2280.08-DRAWING REVISION SCHEDULE

EXISTING SHADOW DIAGRAM - 21 JUNE AT 12PM

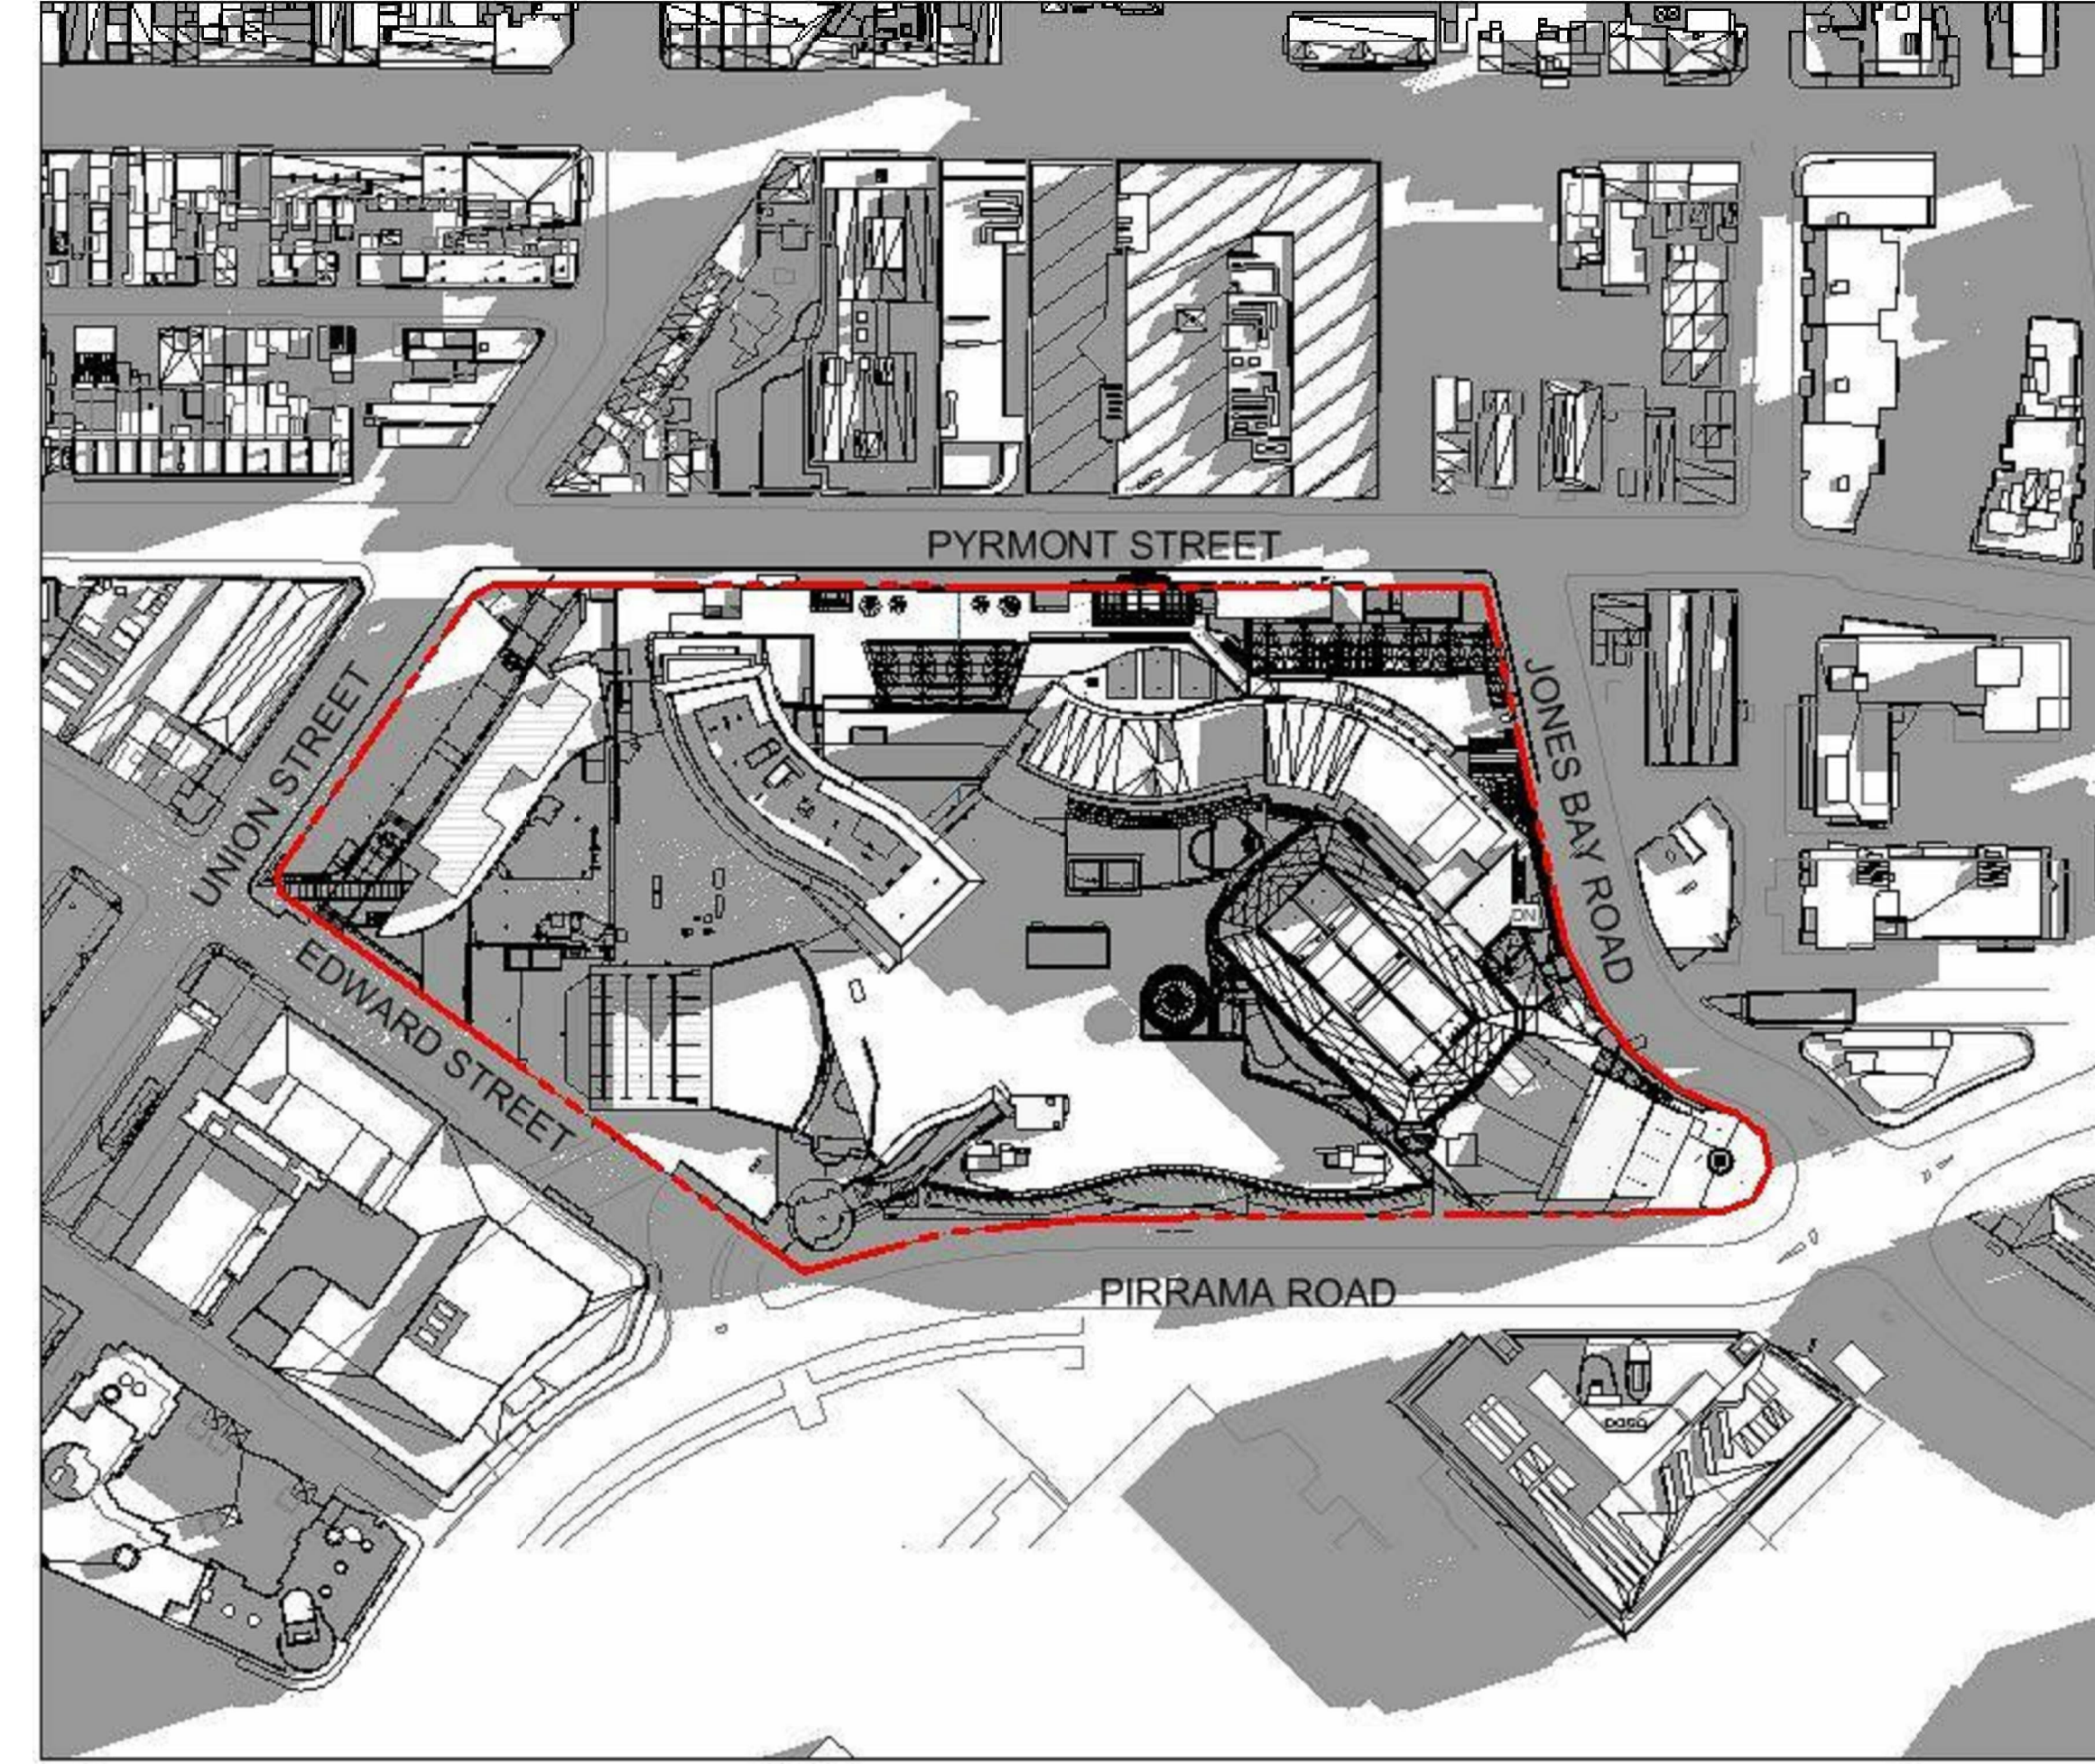
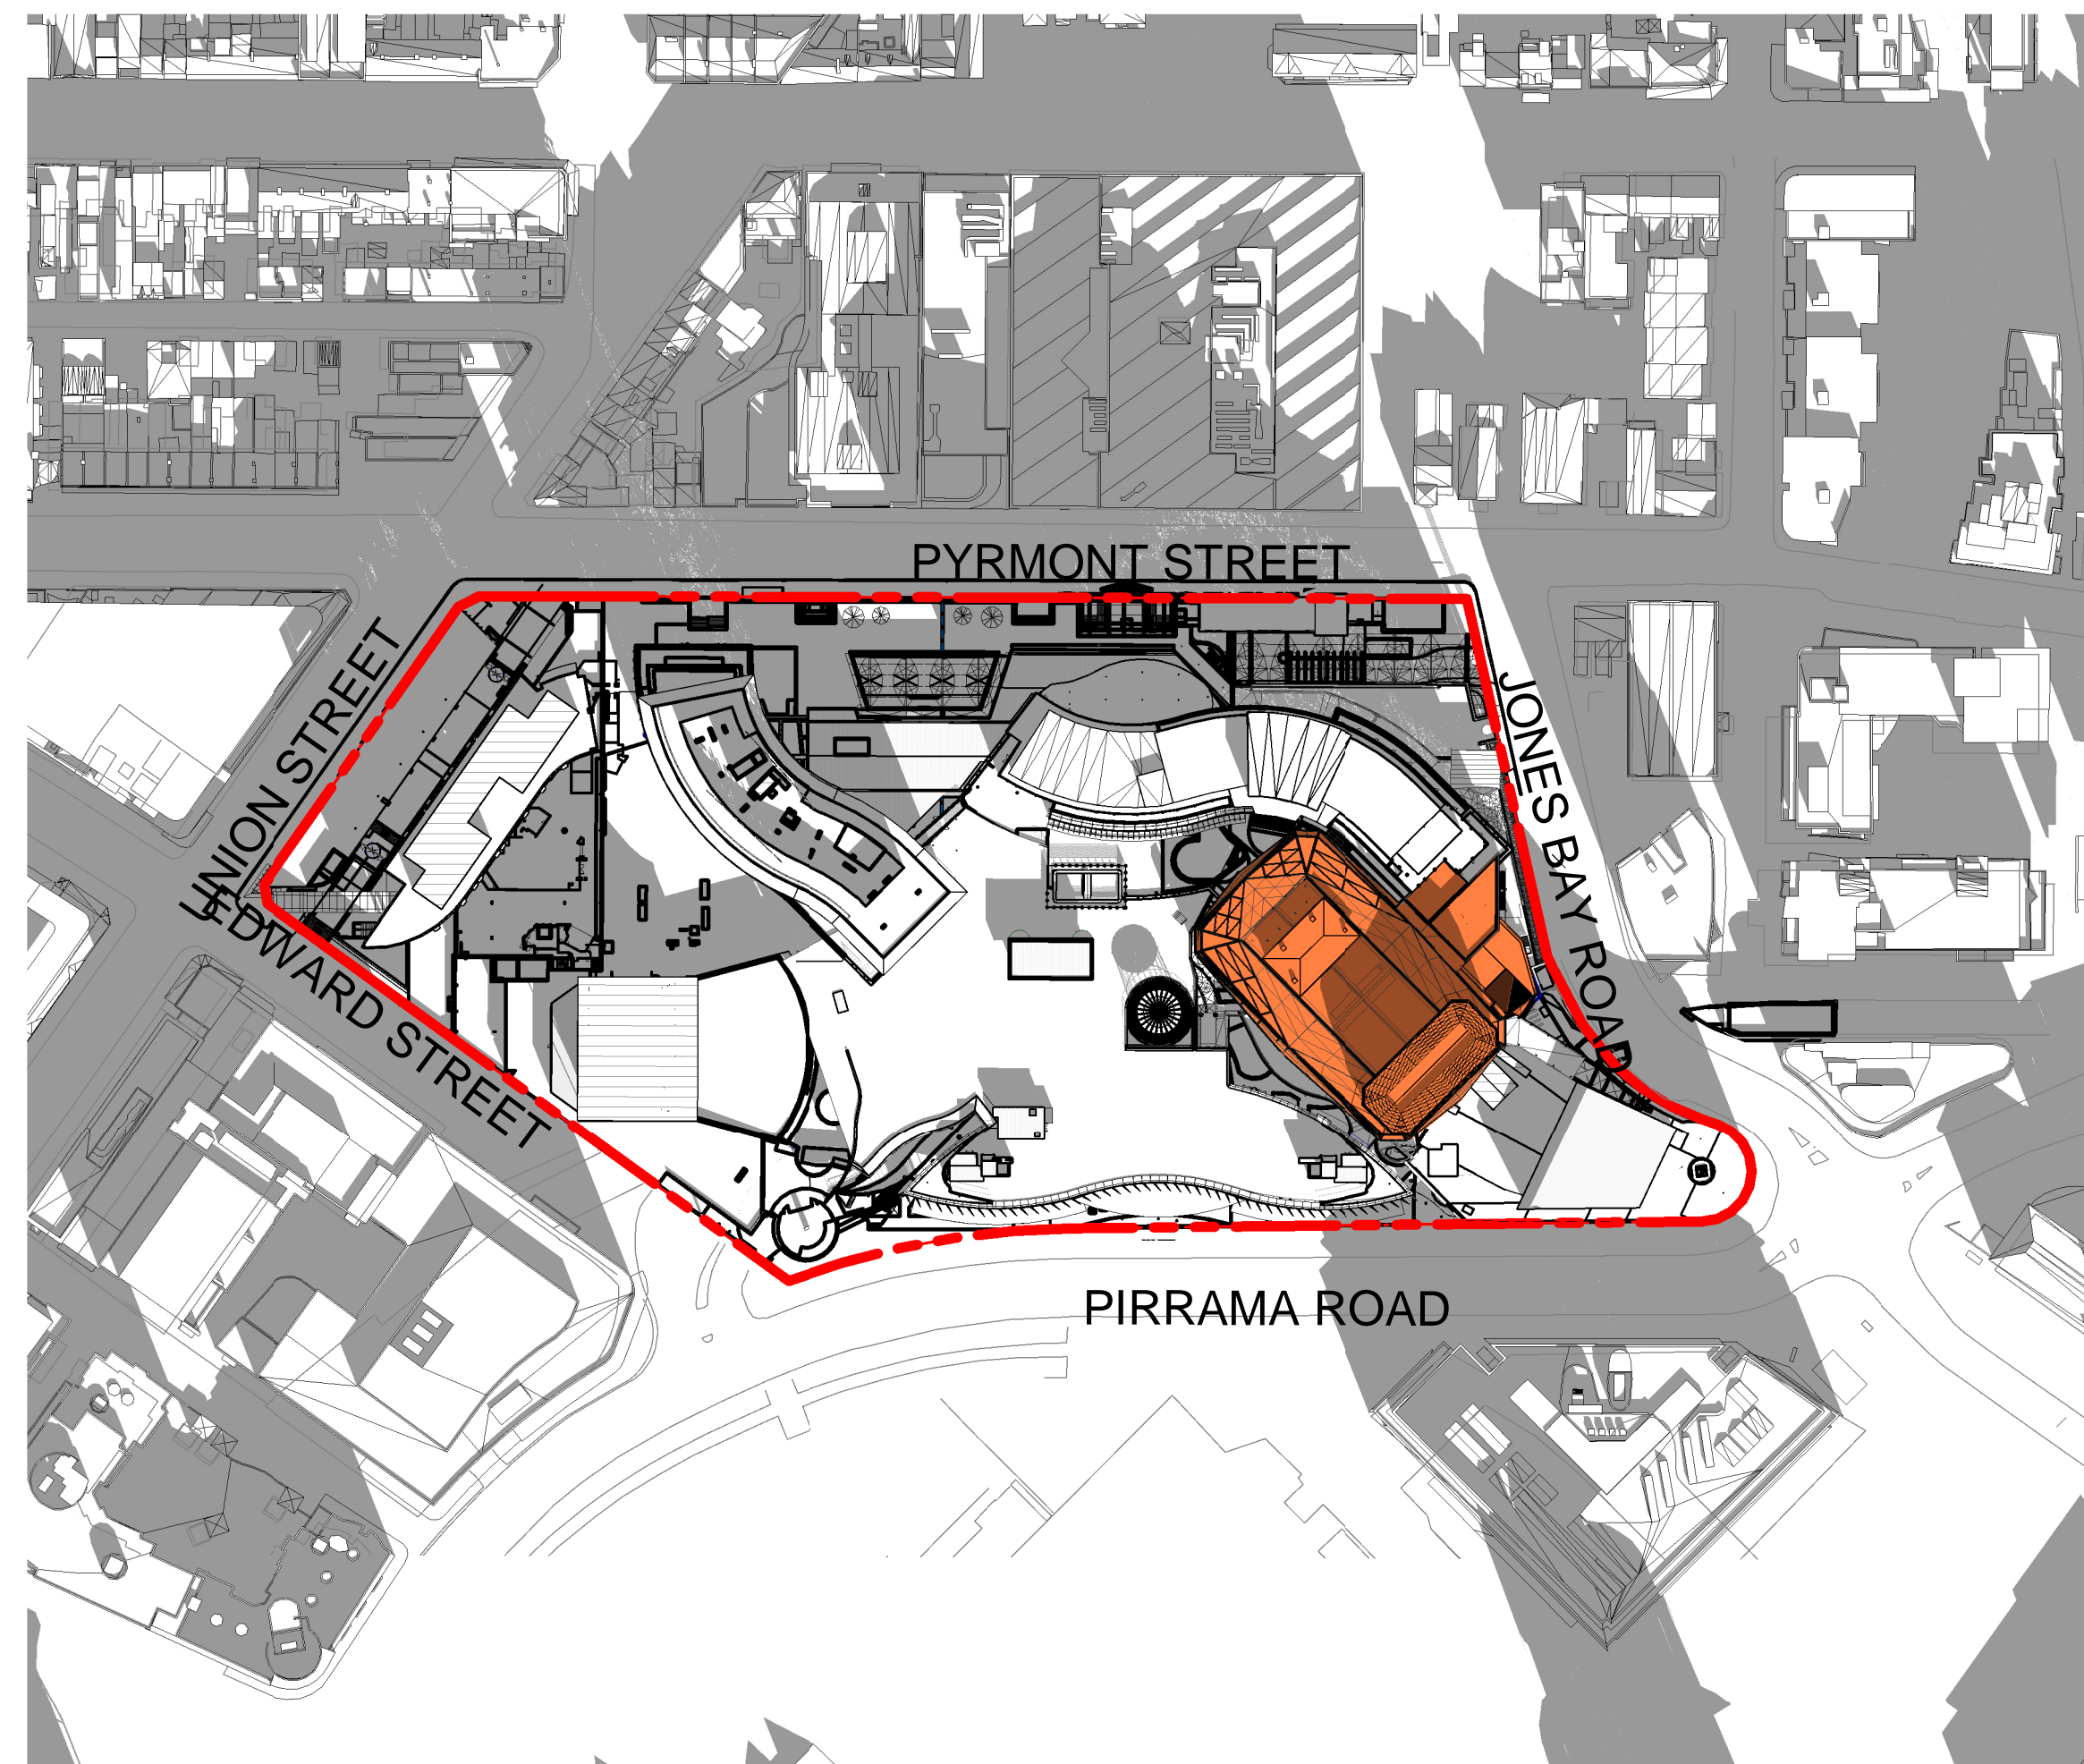
1. Footprint of fly tower reduced to suit comments from DPE and City of Sydney.
2. 4 level extension over existing dressing rooms reduced to 3 levels over existing dressing rooms. Aluminium clad screen extending from 4 level extension and on front of existing plant room omitted.
3. Double height plant room extension omitted from scope.
